## **Gatwick Northern Runway Project DCO (Project Reference: TR020005)**

**Deadline 6 Submission (26 June 2024)**

### **1. Overview**

Figure 1. Reptile Trapping Area A and Receptor AreaSite

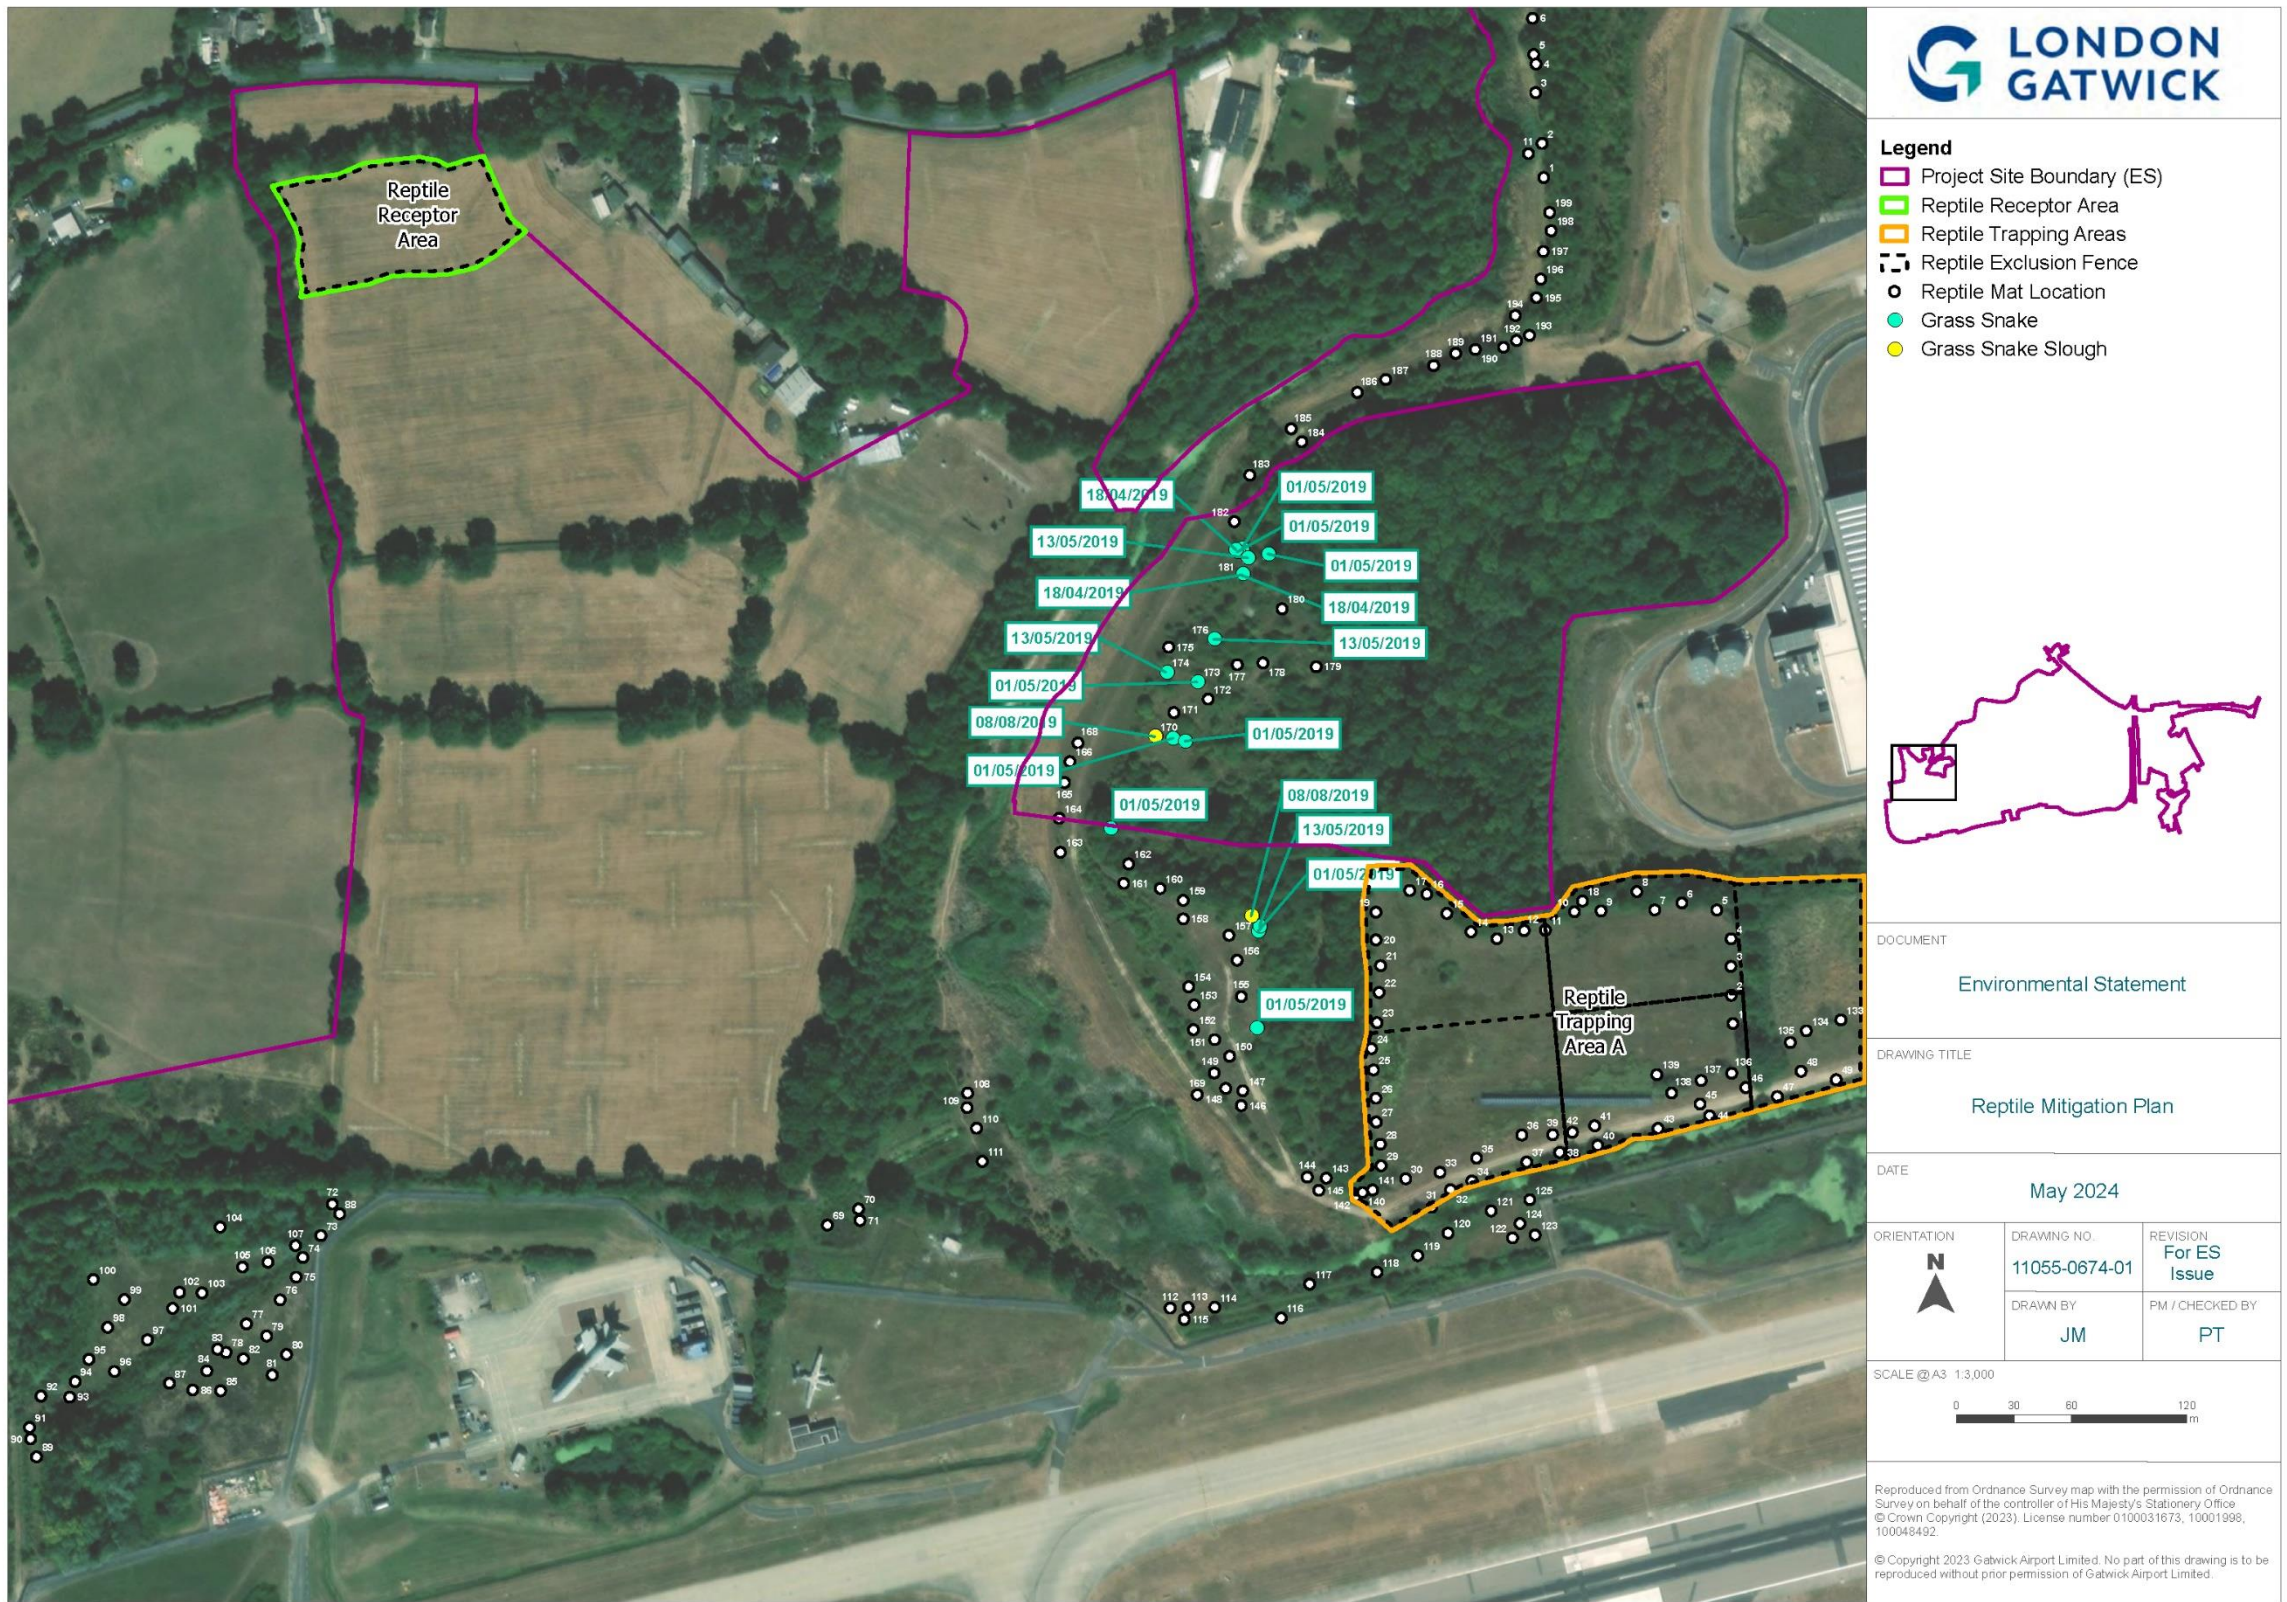
- It would be helpful if the Reptile Mitigation Strategy could include an indicative timescale for the creation and establishment of the Museum Field receptor site. It is critically important that it is created and fully established before any reptiles are released. Whilst the site chosen in Museum Field is existing pasture bounded to the west by mature hedgerow and to the north by the tree-lined Man's Brook, a range of habitat enhancements are proposed, including the creation of species-rich grassland and the planting of mixed scrub and broadleaved woodland. Presumably these habitat enhancements will therefore be undertaken in advance.

- It would also be helpful to understand whether there is any possibility of reptiles being released into the Museum Field receptor site before construction works have ceased elsewhere within the Museum Field/Brook Farm area. If so, measures may be required to exclude reptiles from construction sites.

- Section 2.3.5 suggests that the reptile receptor site will be subdivided into compartments. The purpose of these compartments isn't understood.
- The species and number of reptiles found during any survey, and trapping and translocation exercise, must be fully documented and reported.
